Our ref: RA/2020/141151/01-L01
Your ref: 2019/94165
Date: 05 February 2020

PROPOSAL: DEMOLITION OF EXISTING MILLS AND ASSOCIATED STRUCTURES, ERECTION OF FIVE COMMERCIAL UNITS AND ASSOCIATED YARD WORKS

LOCATION: BUTT END MILLS, CHADWICK LANE, LOWER HOPTON, MIRFIELD, WF14 8PW

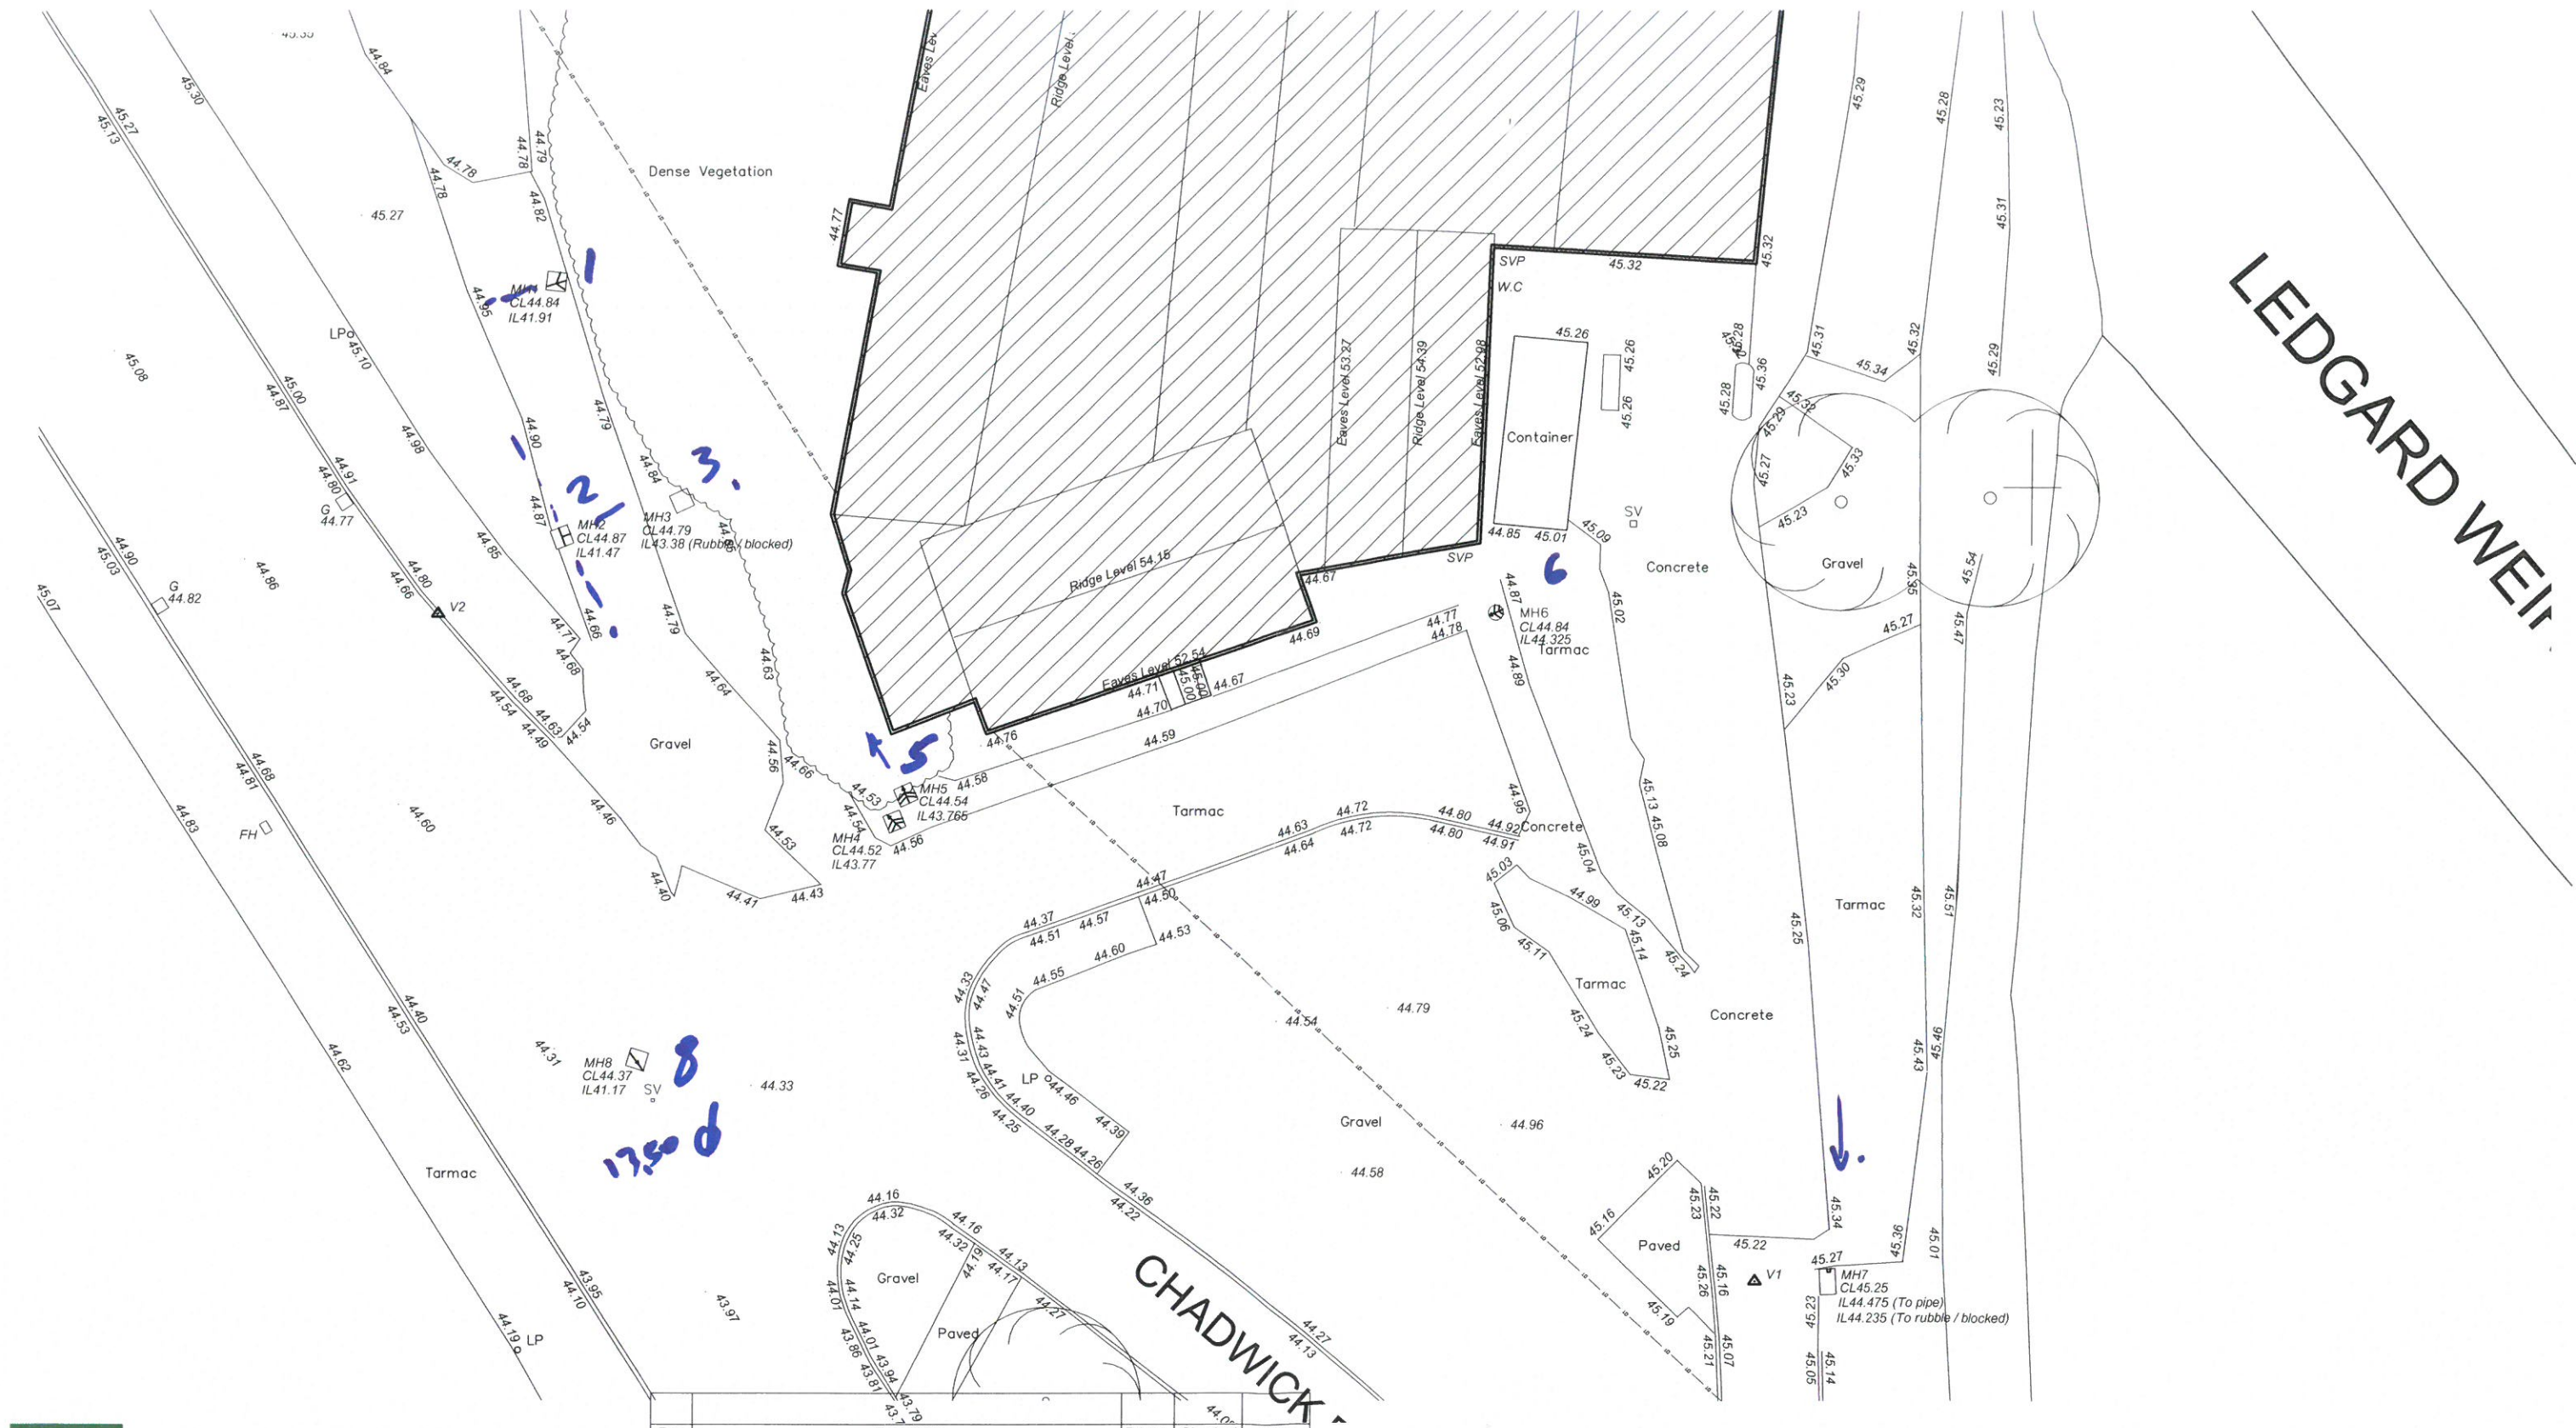
We do note that design drawing number: 0003-Rev P3 'proposed site plan' shows that the proposed re development may encroach in to the 8m buffer zone from the river embankments. Any site layout and design options should take account of the 8 m easement buffer along watercourses where development is not permitted. This easement buffer is recommended by the Environment Agency to allow ease of access to watercourses for maintenance works. We require confirmation on how close parts of the development are to the River Calder in meters.
